From: Simon Davis
Sent: 18 February 2019 14:37

Subject: BR/281/18/PL 99 Victoria Drive, redevelopment with flats

The Group Head of Planning has declined to sign off the report for the Committee. He has a number of concerns:

PROPOSED FIRST FLOOR PLAN

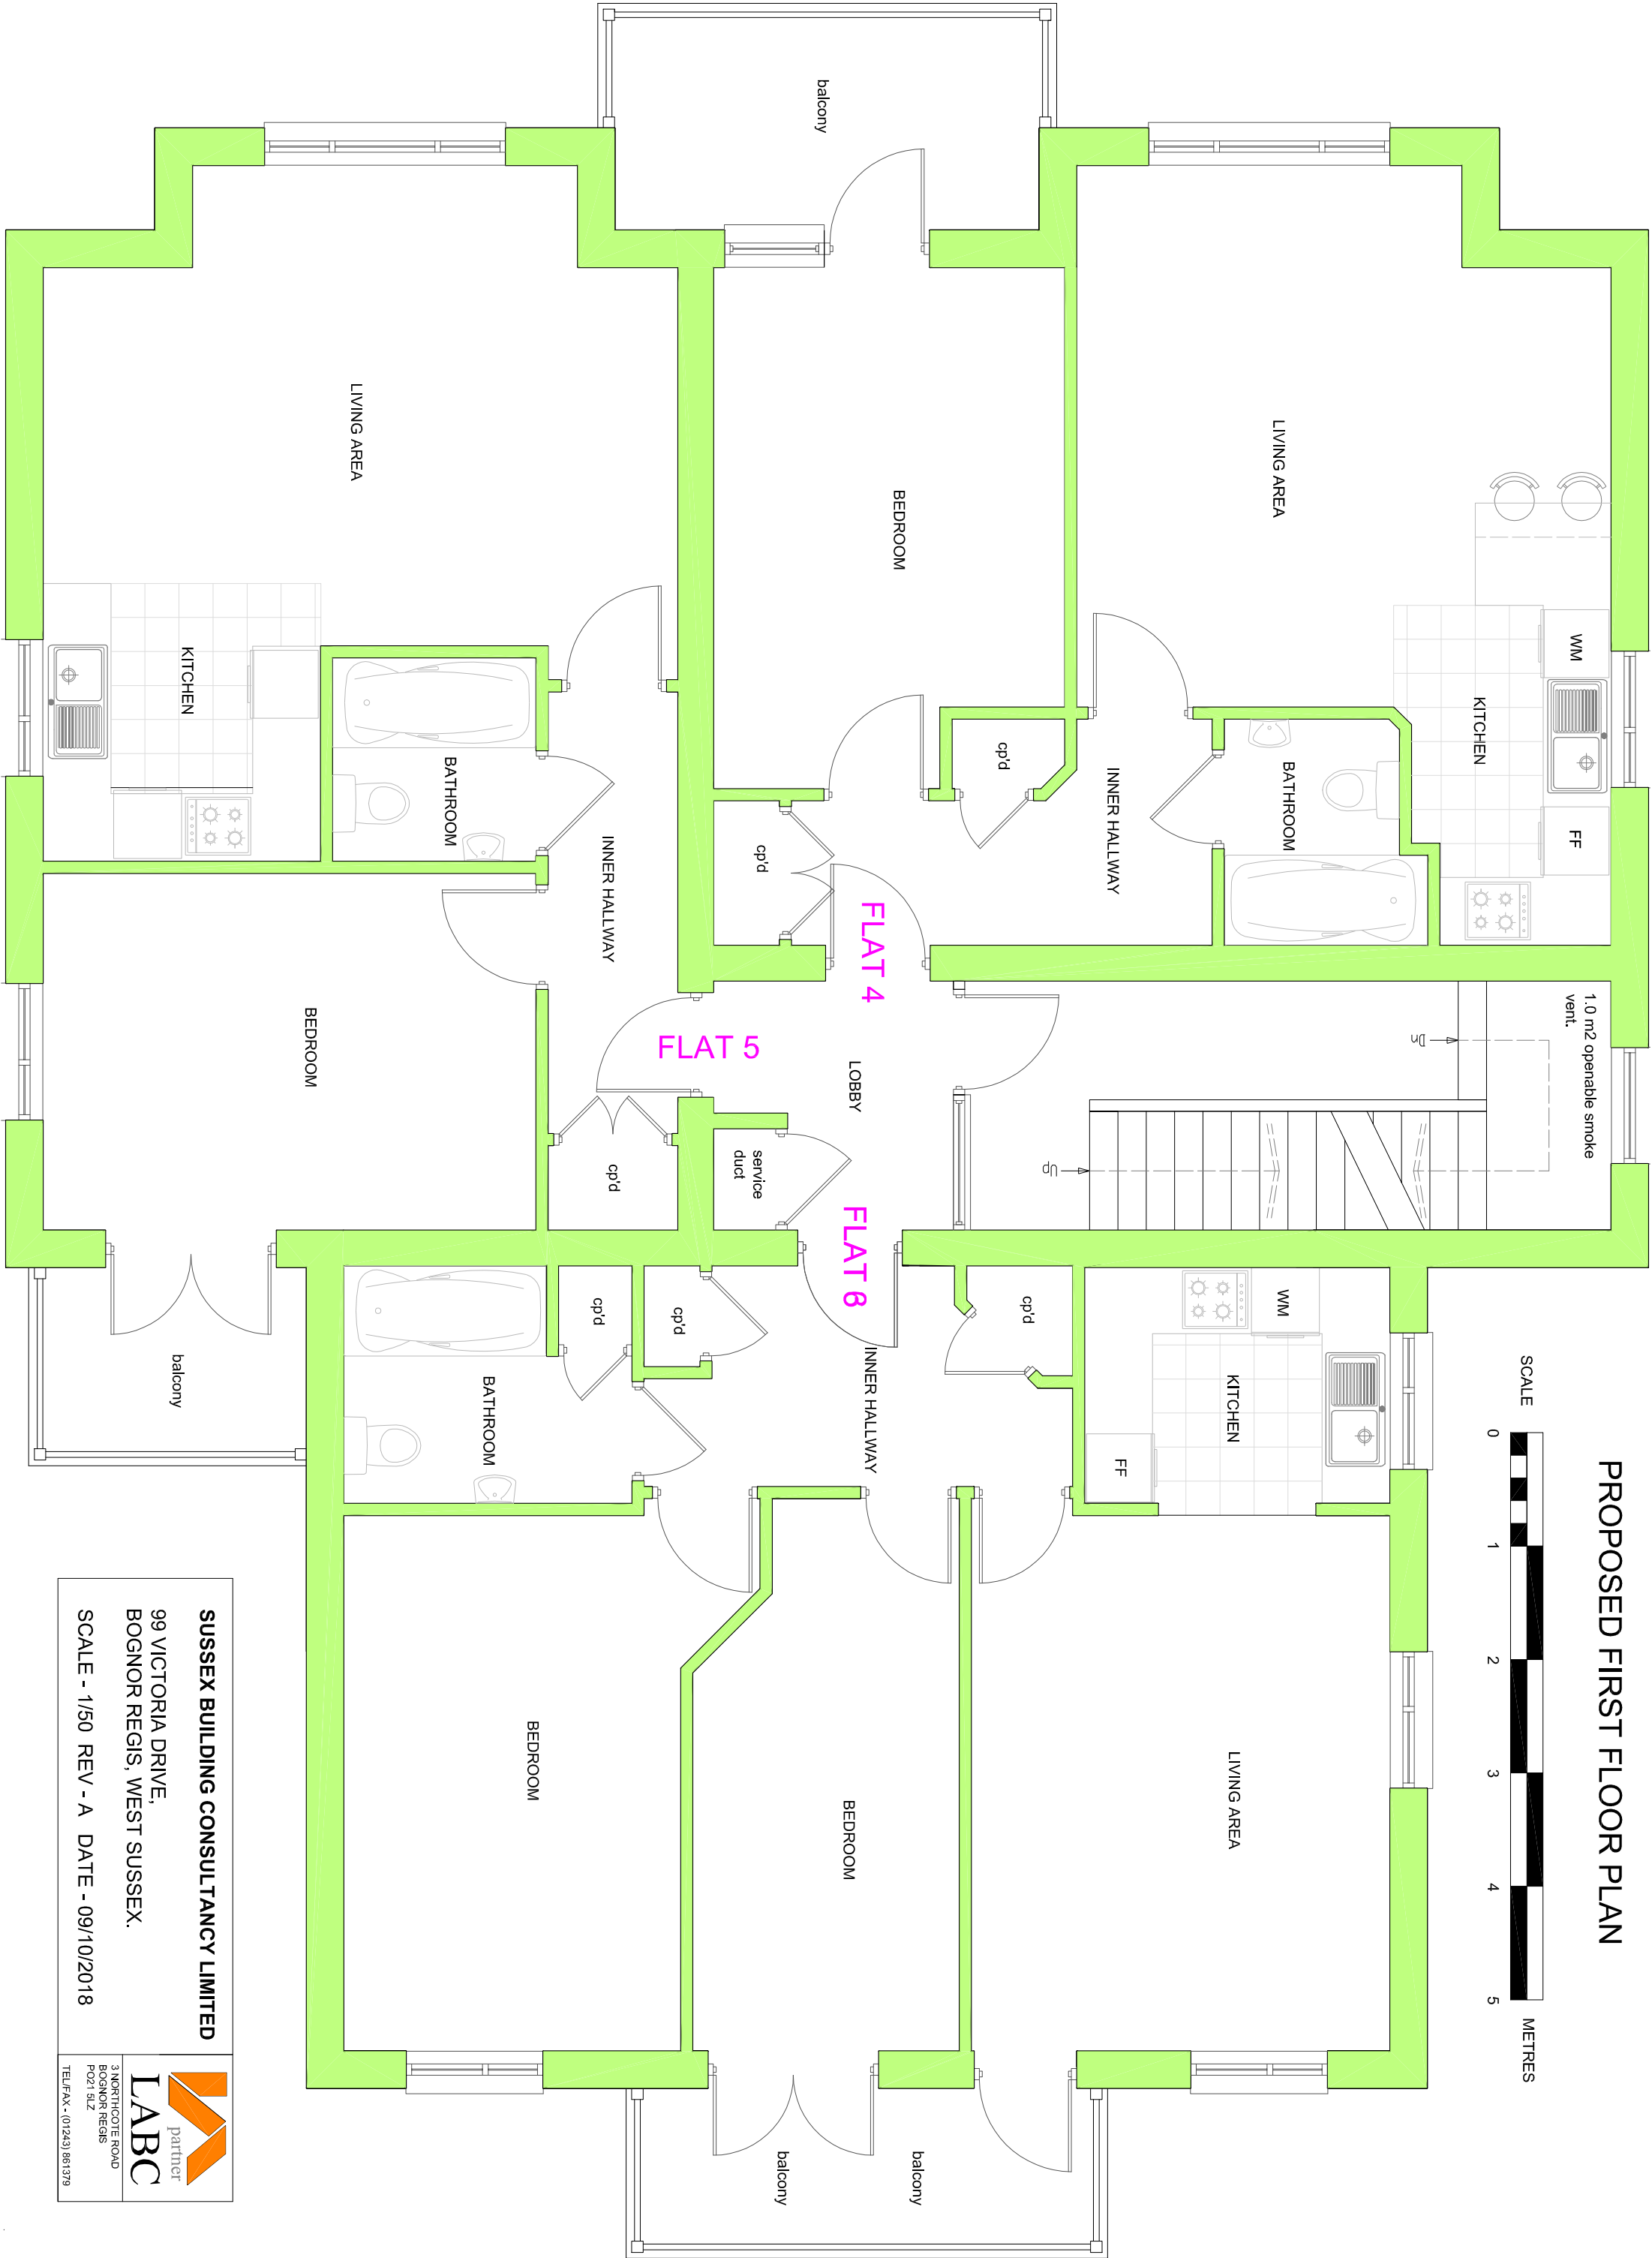
- All windows on the south west elevation of the rear projection need to be removed – not just obscure glazed; and
- I think the above points to the fact that this is too much on too small a site.

PROPOSED GROUND FLOOR PLAN

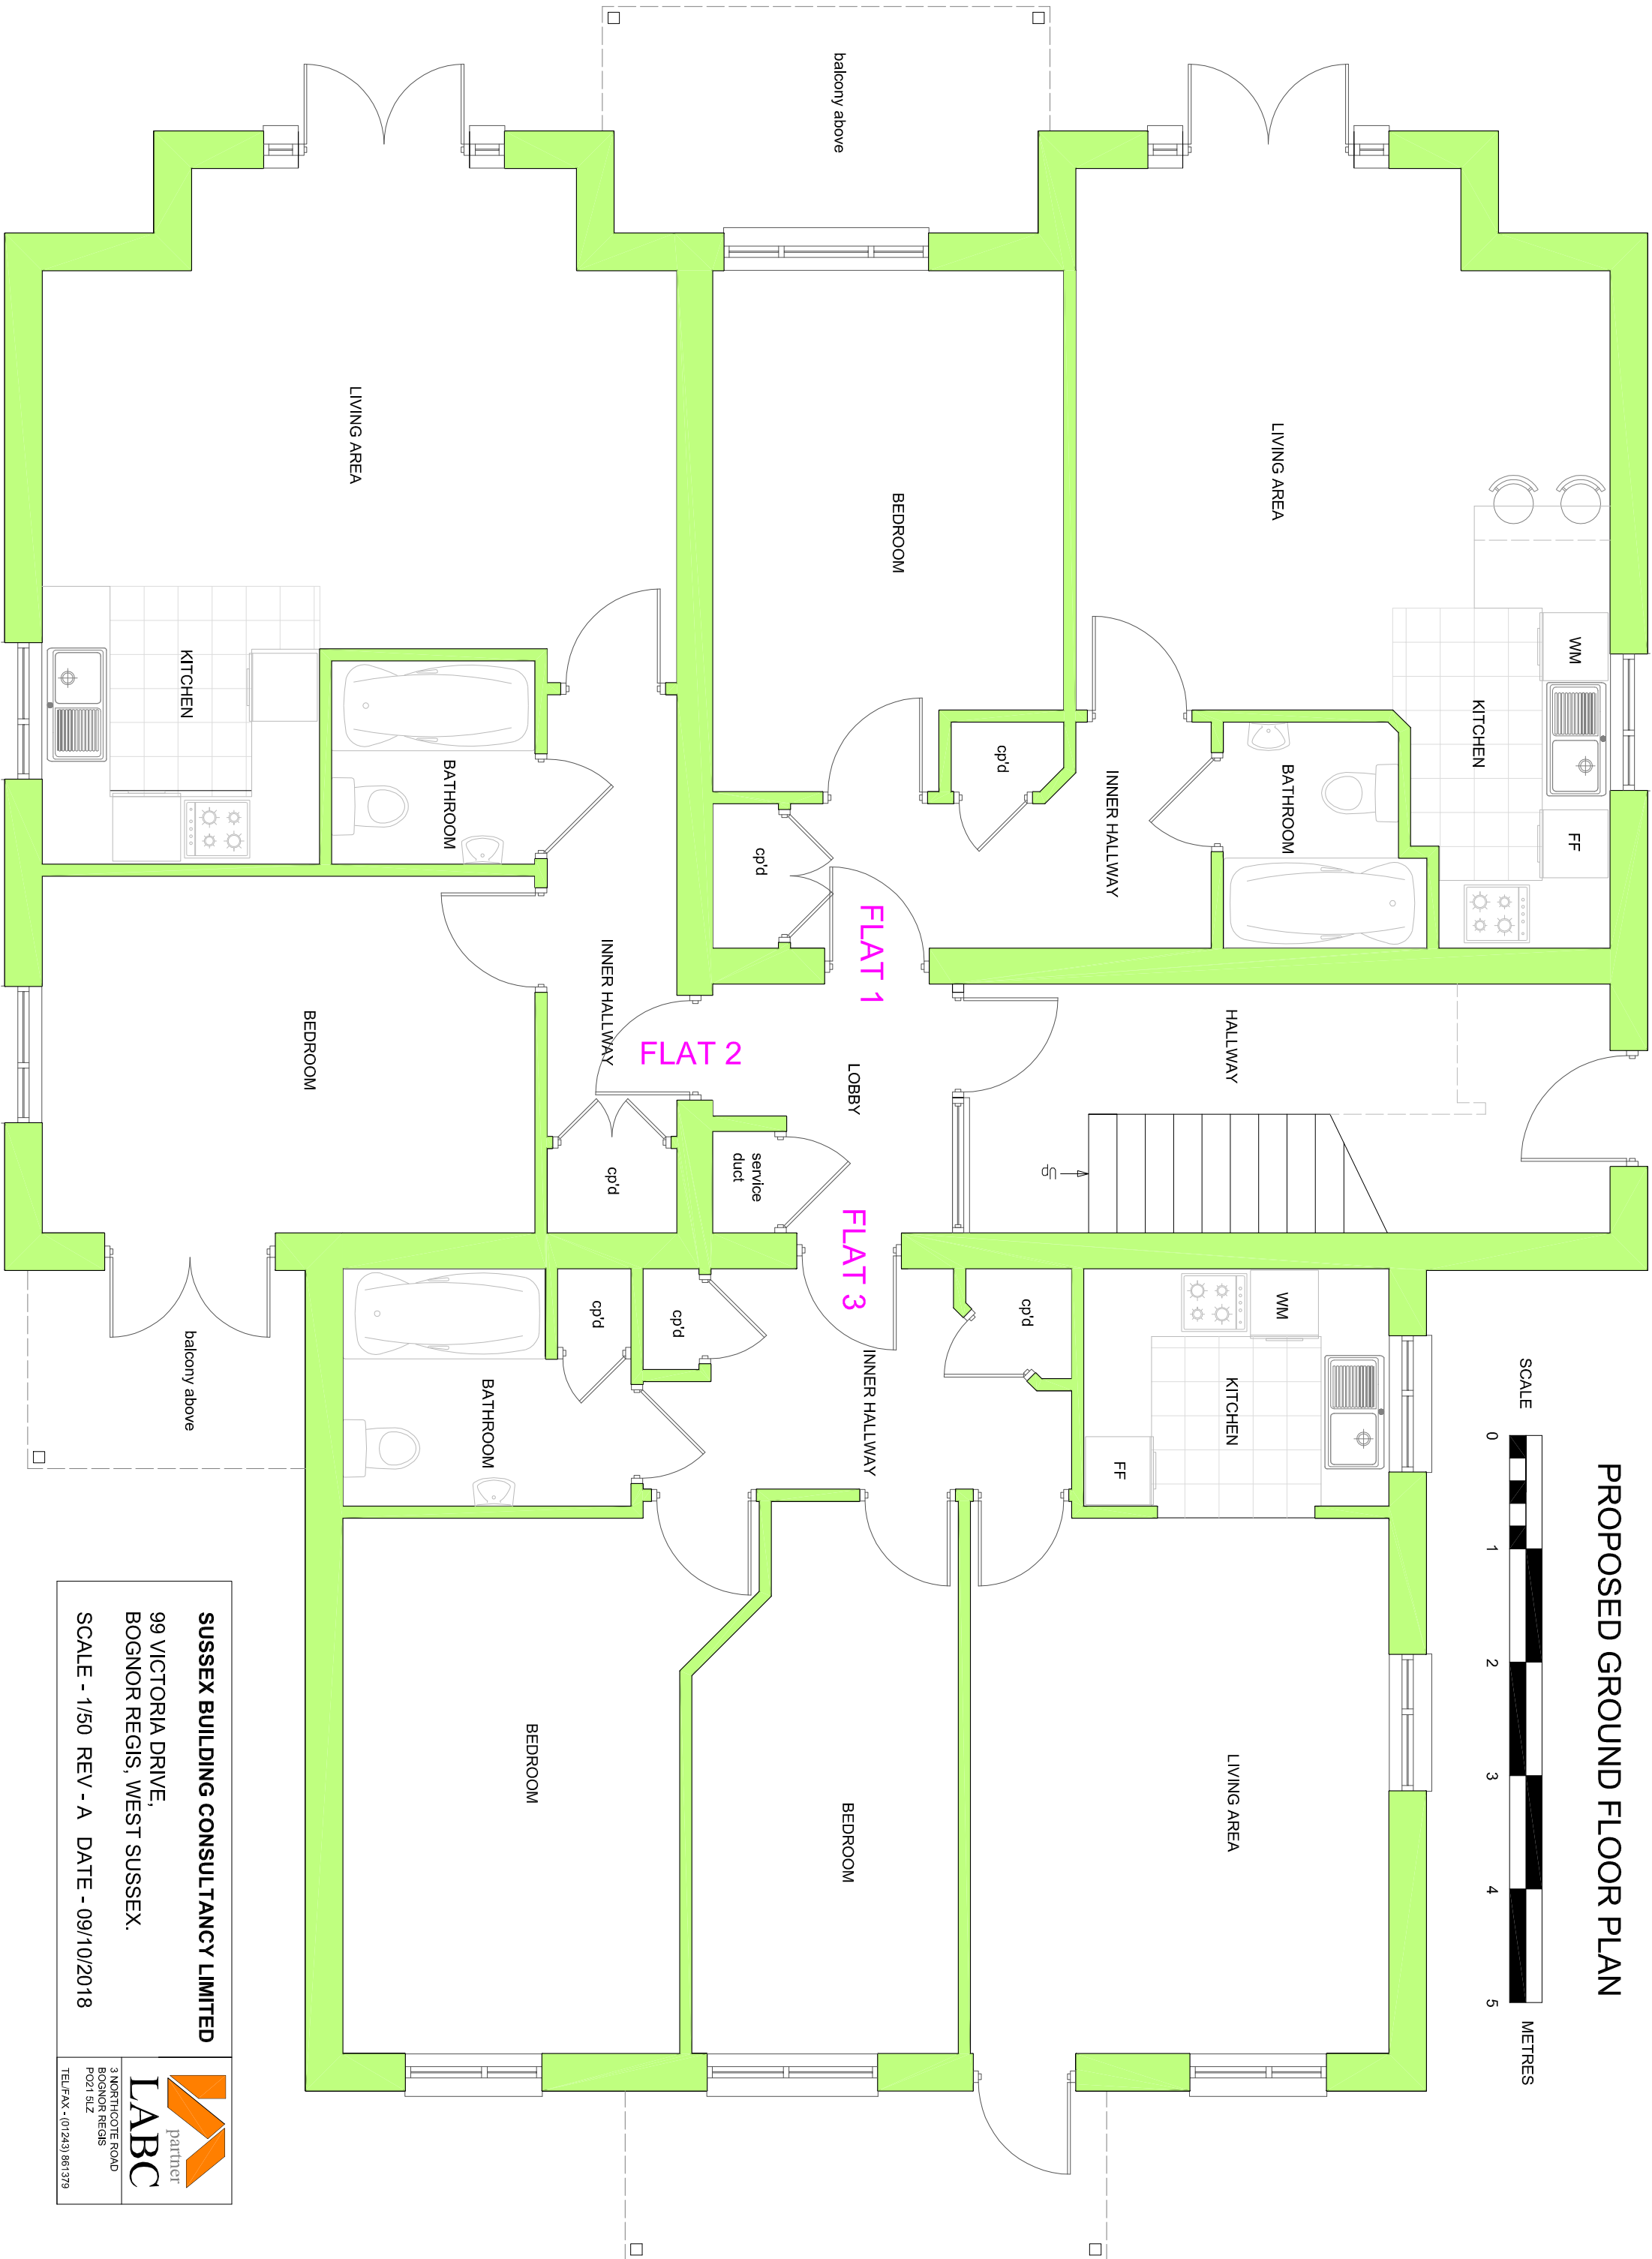
- The parking to the rear and the vehicle movements to the side of a single residential property;
- No other examples of this in streetscene;
- The noise issue is far too quickly dismissed in the report and needs to be addressed – this isn't about a statutory noise nuisance or about noise impact assessments; this is about a change in character and disturbance from moving vehicles and car doors to the rear of residential properties. The parking is right next door to the rear of private residential gardens. I do not agree with our conclusions that this will be acceptable;

PROPOSED NORTH EAST ELEVATION

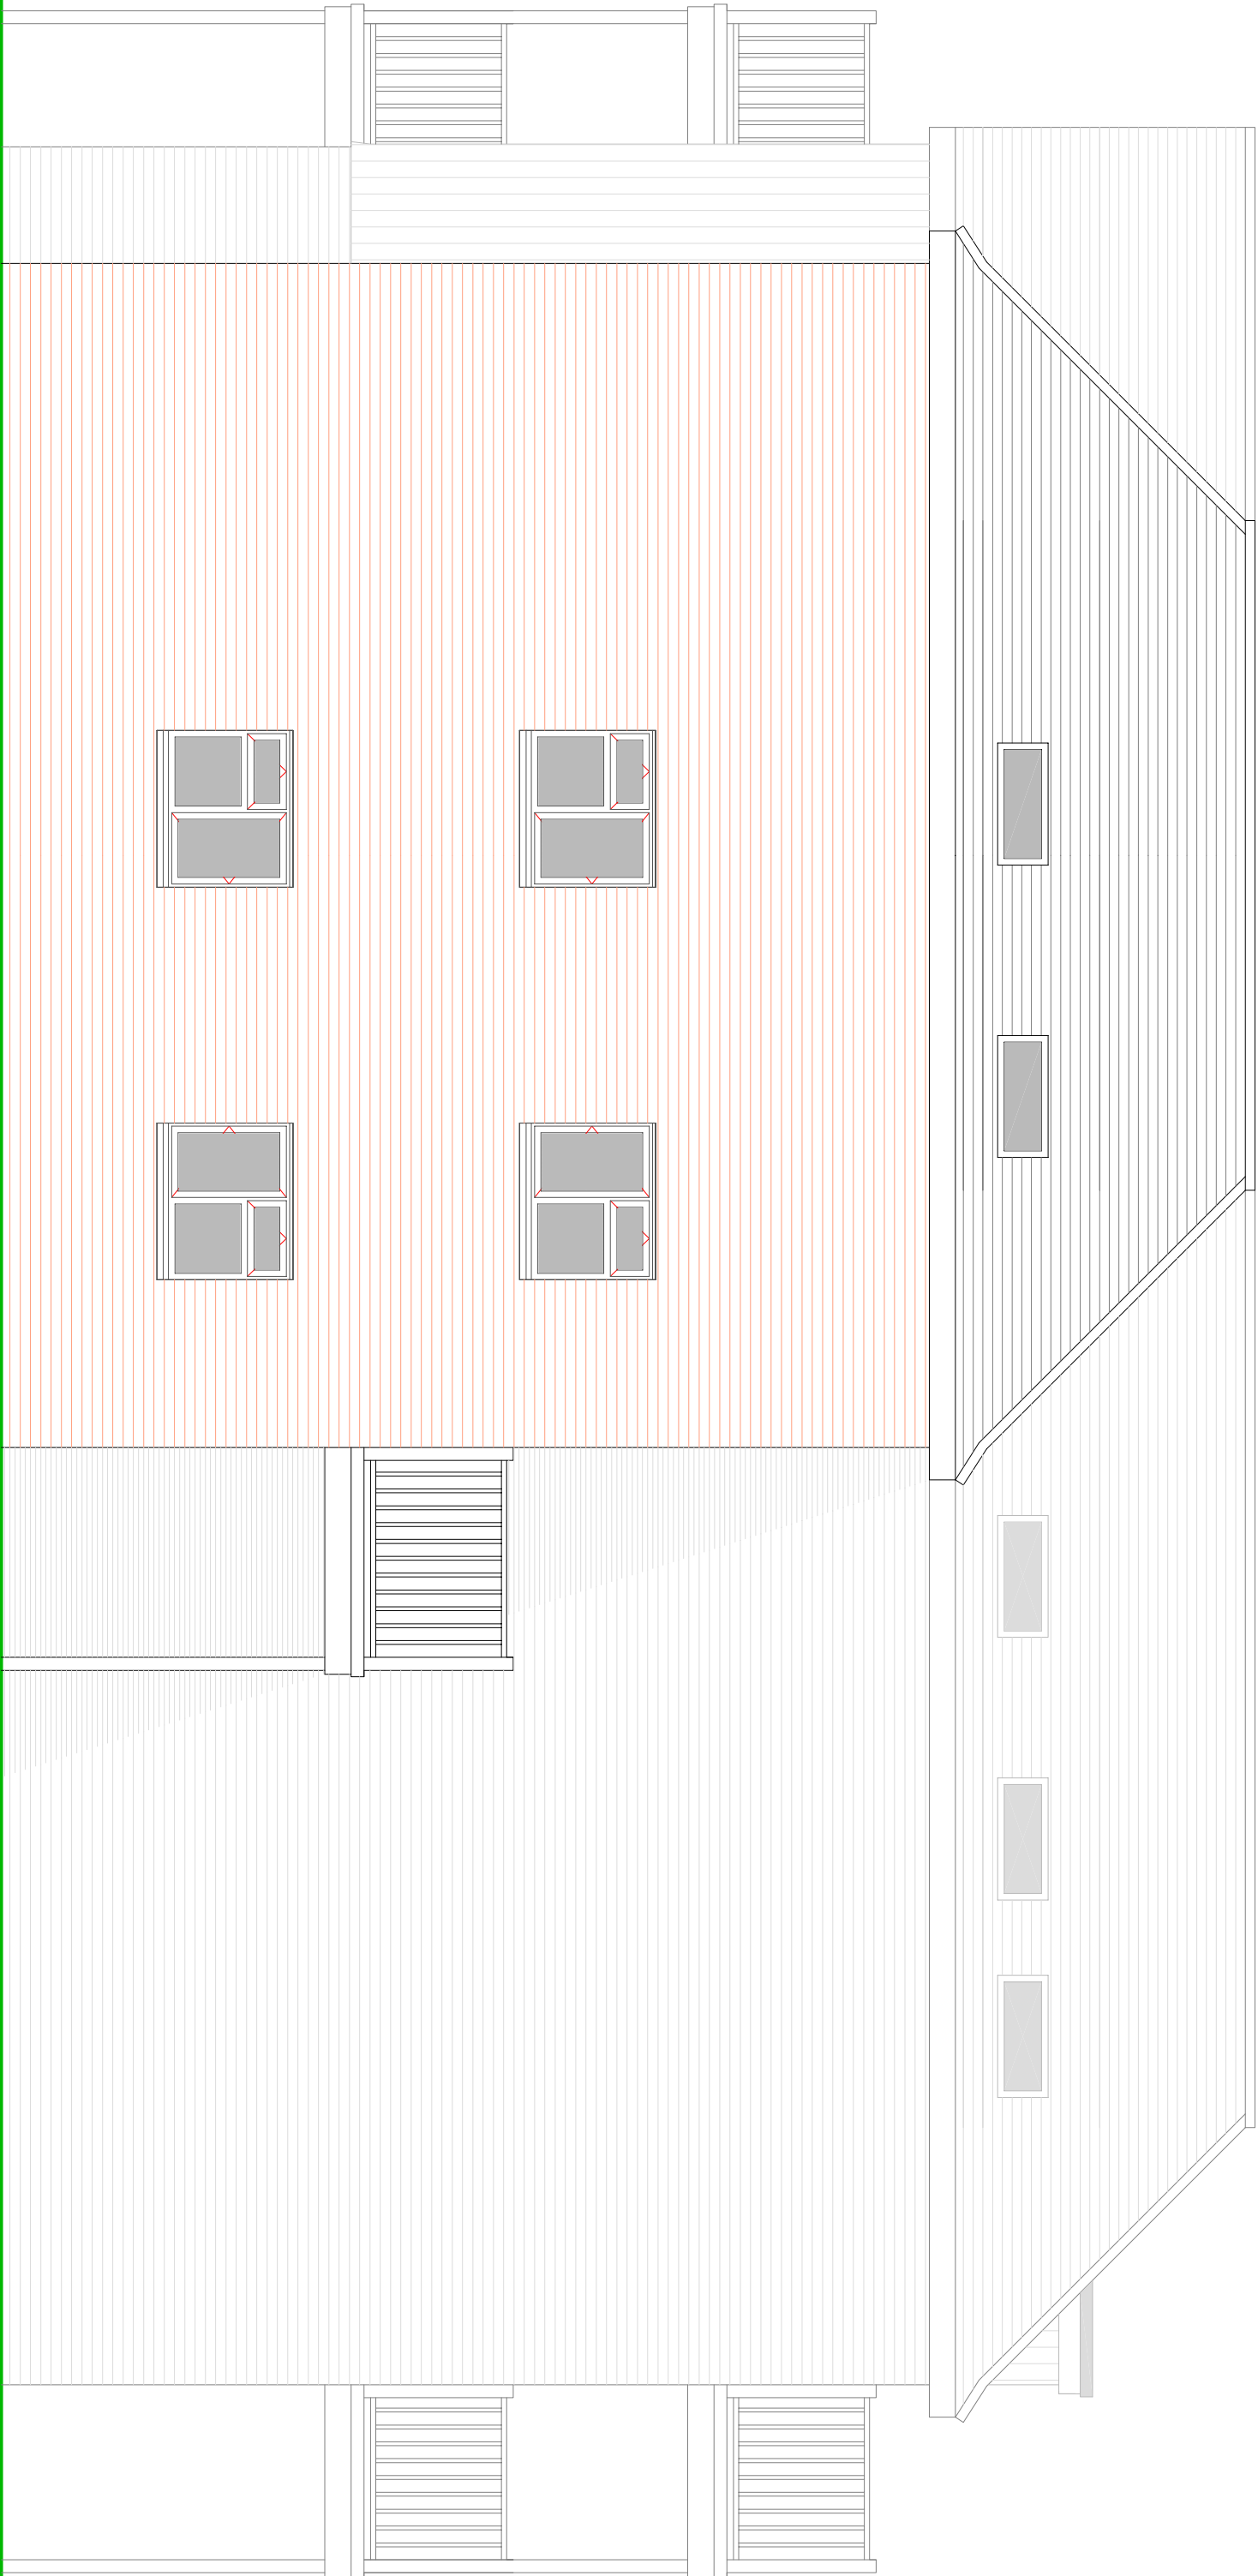
- This proposed building is three stories high and projects 10m to the rear of no.97. I accept the distance separation but put yourself in this garden and think of the scale of that building. That will be over-bearing;
